DOC19/995044-30; EF14/502

**Newcastle Power Station Project (CSSI 9837) Response to Submissions
Further Information Still Required by the Environment Protection Authority**

Attachment A: Further Information Required by the EPA

Figure 6.3: ISR vs in-stack NO_x concentration from filtered US EPA ISR database

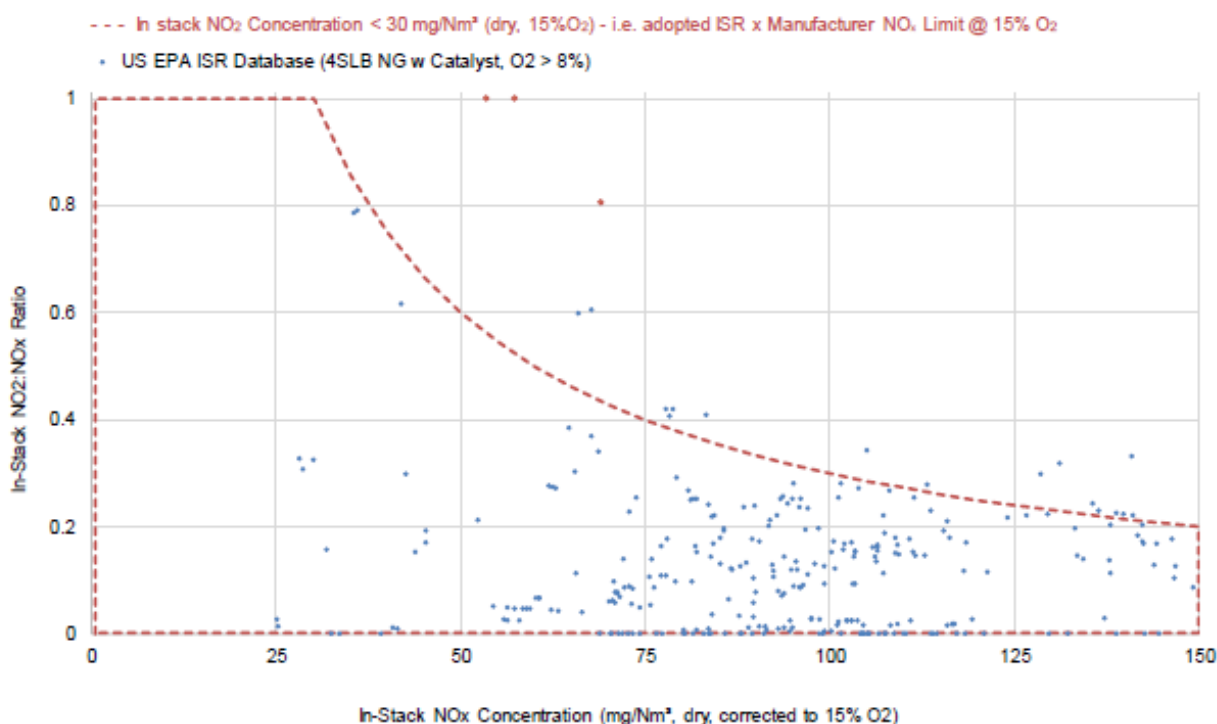
The benchmarking of control technology and NO_x emissions has not considered the application of best available technology and achievable emissions levels from experience in other jurisdictions. Given that NO_x is an ozone precursor and that the proposed power station would be in an ozone non-attainment area, NO_x emissions should be as low as reasonably and feasibly achievable. Further, as NO_x is a precursor to secondary particle formation and the proposed power station would be in a PM_{2.5} non-attainment area, NO_x emissions should be as low as reasonably and feasibly achievable.

Achievable emission levels for NO_x have been demonstrated to be significantly lower than those referenced and proposed in the RTS AQIA benchmarking. This is demonstrated in the AQIA's figure 6.3 which shows in stack NO_x emissions, which are not necessarily best practice, are generally far less than 100 mg/m³ (@ 15 % O₂) and therefore the proposed 150 mg/m³ is not best practice (Figure 6.3 reproduced below).
